Item	Issue	Comment/Action
	Office of Environment and Heritage	
1	<p>Biodiversity OEH has reviewed the Biodiversity Development Assessment Report provided with the EIS.</p> <p>We note that no PCTs (ecosystem credits) or threatened species credit species were recorded within the Development Site.</p> <p>We concur with the assessment that no offsets are required for the proposed development under the Biodiversity Conservation Act 2016.</p>	Noted.
2	<p>Aboriginal cultural heritage Based on assessment of the information provided in the EIS and Wagga Wagga Base Hospital Baseline Archaeological Assessment Report (Amended 2012), consideration of potential impacts to ACH as a result of the proposed development activities has been demonstrated and is largely consistent with the requirements identified by the SEARs issued for SSD 9033.</p> <p>Mitigation Measures (Unanticipated Finds Protocol) We note and support mitigation measures described in EIS Section 6.6 (Aboriginal Heritage) but consider this has not completely translated to Table 8 (Mitigation Measures) and is not inclusive of a protocol for the chance encounter of skeletal remains.</p> <p>We recommend the following as a condition of

Figure 3.2: Proposed reinstated car parking spaces under existing demountable building (south of CP3)

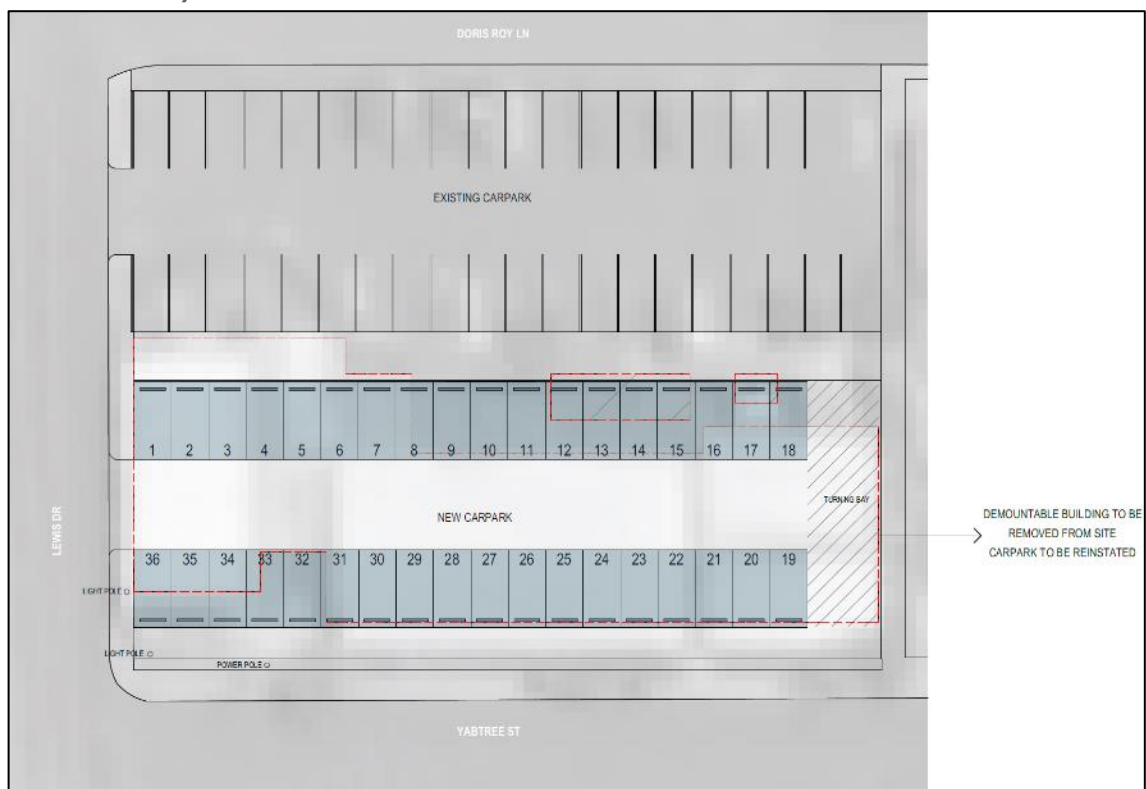
36	<p>With respect to the statement regarding DCP compliance, the applicant's claim that the reinstatement of 36 existing spaces (under the demountable buildings) contribute to this compliance should be examined. These are spaces that were originally available to the hospital that were temporarily removed to allow for earlier stages of construction. It is unclear from information provided within the application as to whether these spaces were ever replaced elsewhere on site as part of the placement of the demountable buildings. If they were not, it is questioned as to whether they should be credited towards that required for the Stage 3 project.</p>	<p>We confirm that the 36 car parking spaces were not included as part of the previous SSD DA, which required 440 spaces. Accordingly, the 36 spaces under the demountable buildings are in addition to the requirements of the previous status of the Hospital and are appropriate to count as additional for the purposes of the Stage 3 SSD DA.</p>

**Figure 7.3: Edward Street/ Murray Street intersection upgrades due to background traffic growth**

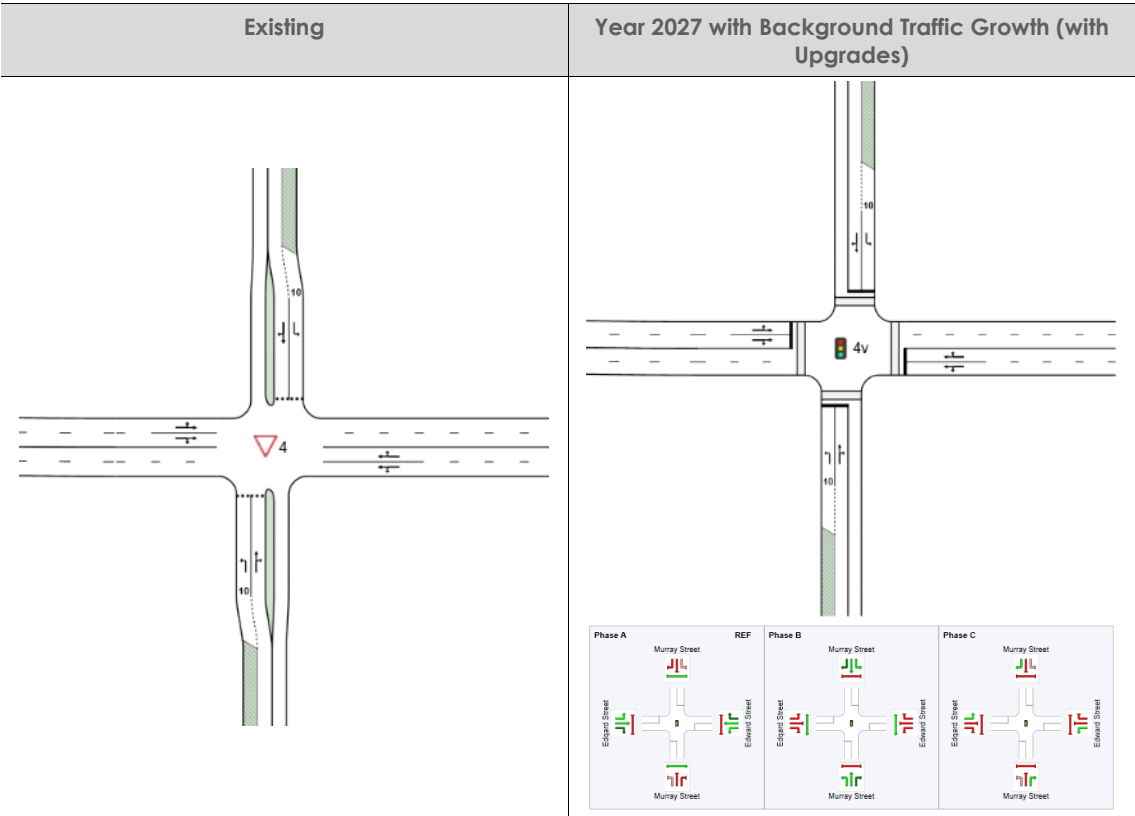
18	<p>Due to the proposed access routes to the hospital site and the anticipated traffic generation it is considered that the road network within the surrounding precinct, particularly Murray Streets, and its intersection with Edward Street, need to be assessed with acknowledgement of the traffic loadings resulting from the whole redevelopment and appropriately treated to safely manage the increased traffic levels. To further increase the volume of traffic (both vehicular and pedestrian) through this intersection without appropriate intersection treatment will increase the potential for serious incidences at this intersection. The intersection of Murray and Edward Street currently has a crash history. The proposed treatment to deny right turn from Murray Street as proposed does not address the potential traffic issues.</p>	<p>An updated assessment of the surrounding street network has been prepared by GTA and is provided at Appendix C.</p> <p>A traffic workshop was held with HI, RMS and Council on Thursday 27 September 2018. The outcome of this workshop was shared acknowledgement that improvements are required at the intersection of Murray Street / Edward Street. It was resolved that RMS and Council would be unlikely to approve the interim recommendation of installing left turn only arrangements at Murray Street / Edward Street and Brookong Street / Edward Street, even if additional analysis was undertaken. HI, RMS and Council committed to undertaking ongoing meetings and collaboration regarding an intersection arrangement for Murray Street / Edward Street that would provide a LOS C operation for 2031.</p>

19	<p>The development should be conditioned to upgrade the intersection of Edward and Murray Streets with consideration for both vehicular and pedestrian traffic however the selection of the appropriate treatment and the level of contribution towards such works will require further investigation and discussion between the proponent, Roads and Maritime Services and the Wagga Wagga City Council.</p>	<p>A traffic workshop was held with HI, RMS and Council on Thursday 27 September 2018. The outcome of this workshop was shared acknowledgement that improvements are required at the intersection of Murray Street / Edward Street. It was resolved that RMS and Council would be unlikely to approve the interim recommendation of installing left turn only arrangements at Murray Street / Edward Street and Brookong Street / Edward Street, even if additional analysis was undertaken. HI, RMS and Council committed to undertaking ongoing meetings and collaboration regarding an intersection arrangement for Murray Street / Edward Street that would provide a LOS C operation for 2031.</p>
